From: Alison Crabb [REDACTED]
Sent: 09 July 2018 10:18
To: Planning.Responses
Subject: RE: Planning Consultation on: BN/23/18/PL

BN/23/18 – 37 Hill Lane

Description of Works: Redevelopment of brownfield site previously used for A1 retail to 3 No. dwellings, detached garage & associated works. This application is a Departure from the Development Plan.

1088/DPA03

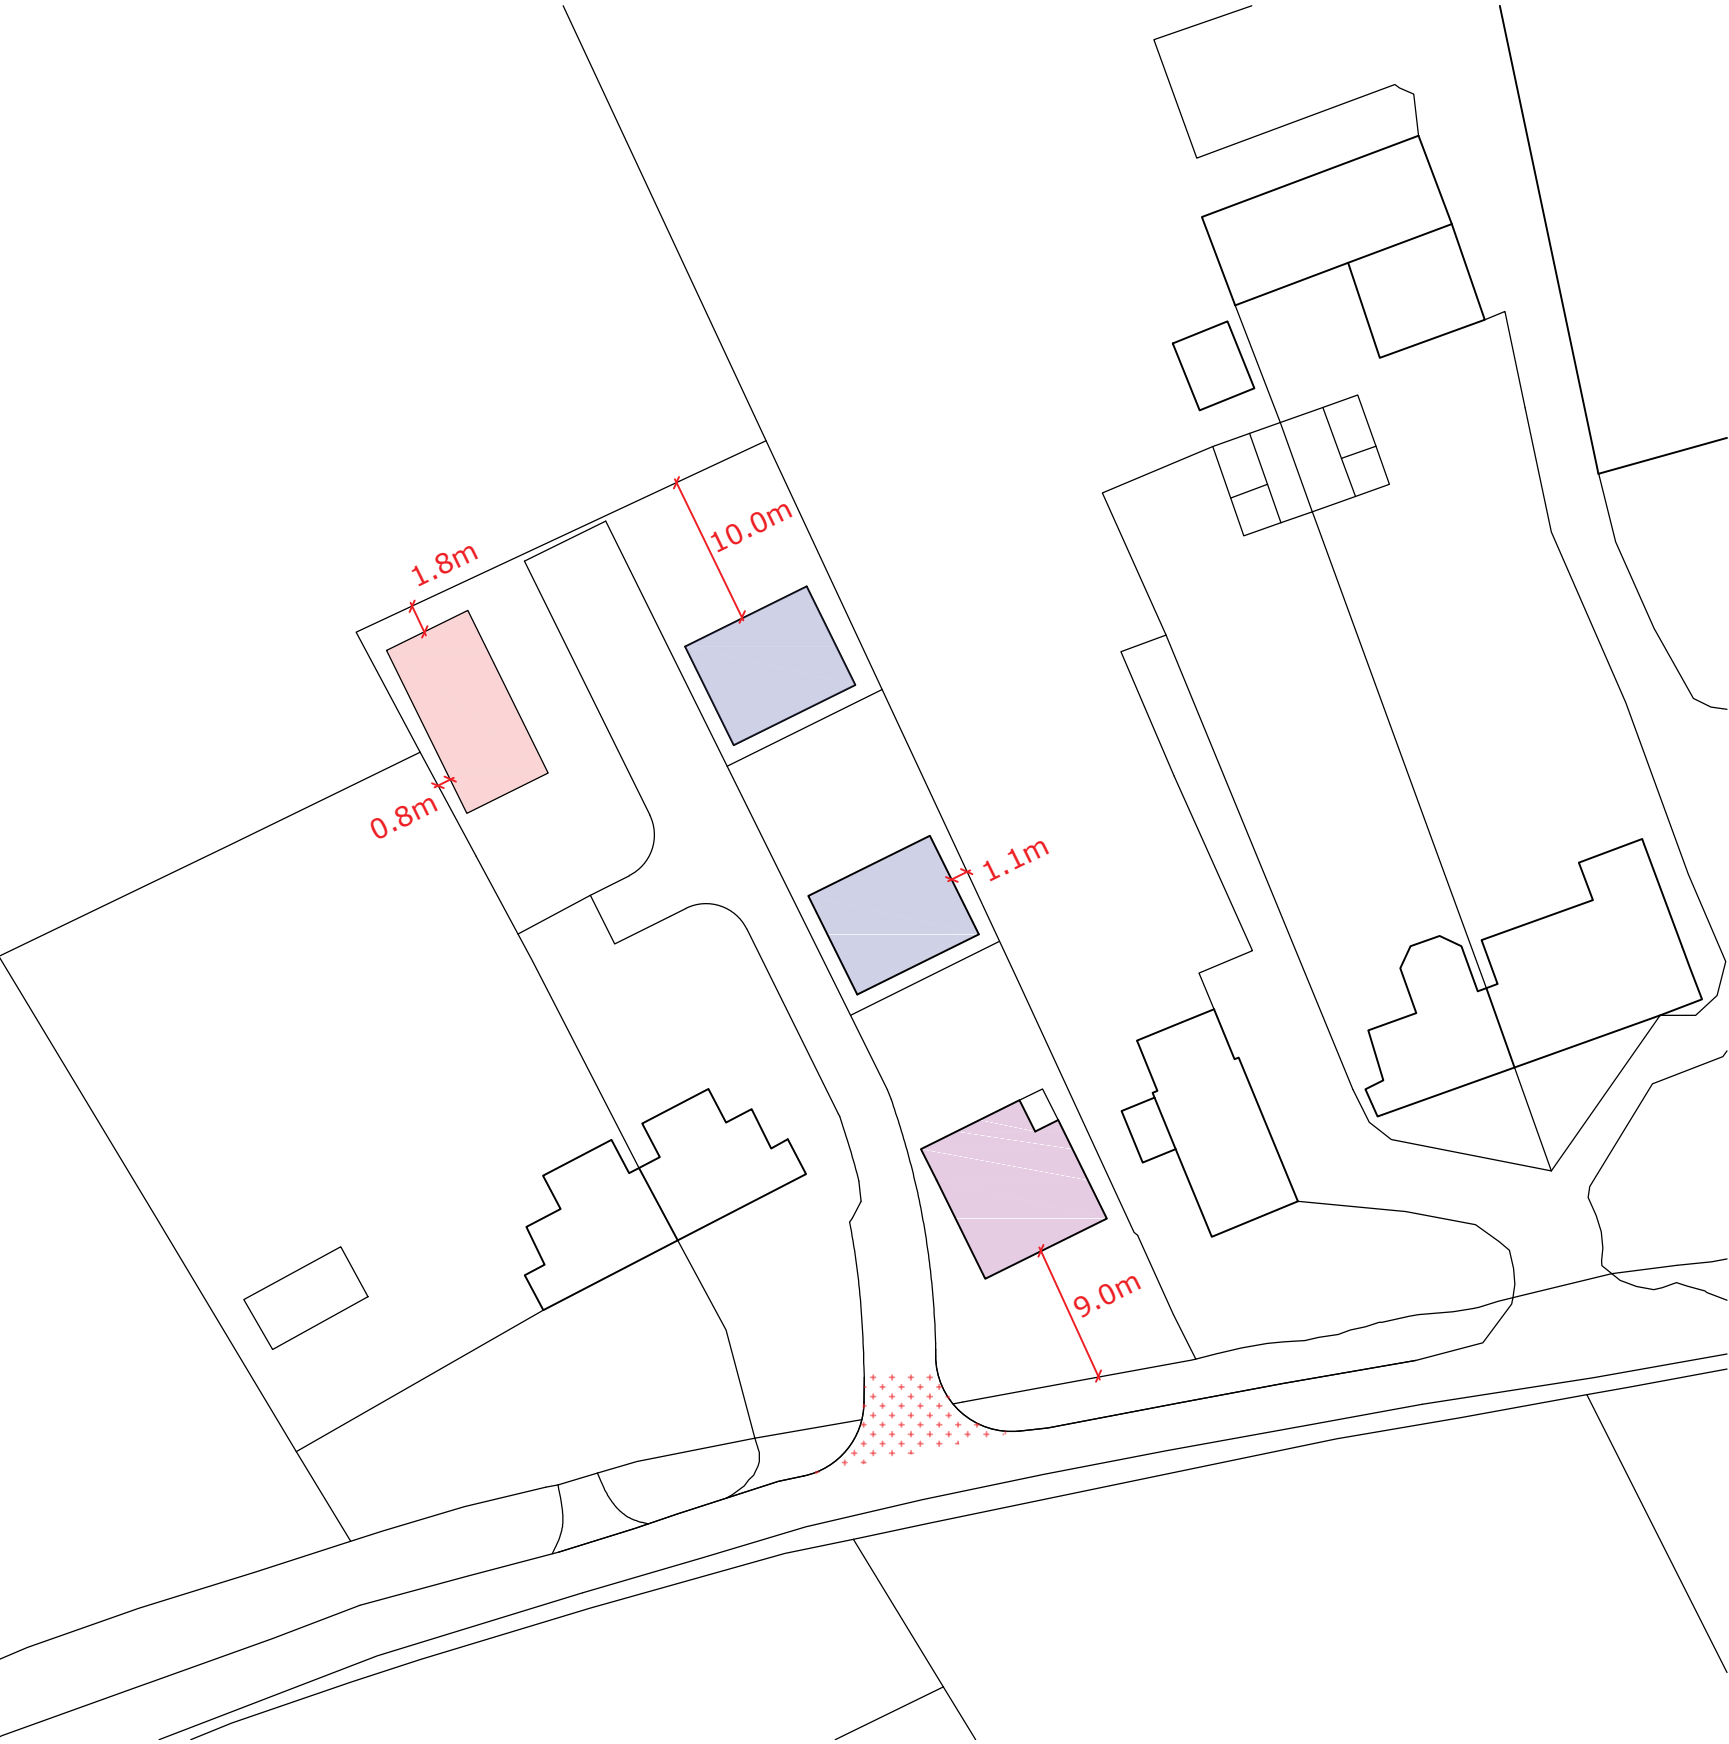
In particular the Council consider the number and size of houses to be an over-development of the site. The impact of the design of the properties on the surrounding area and the fact that they do not follow the building line of other houses along the road – Policy H4 Integration of new housing into surroundings refers. A plan for dealing with the surface water drainage (Policy ES1 Flooding, drainage and new development) would be required in particular in respect of discharging into the local ditch.
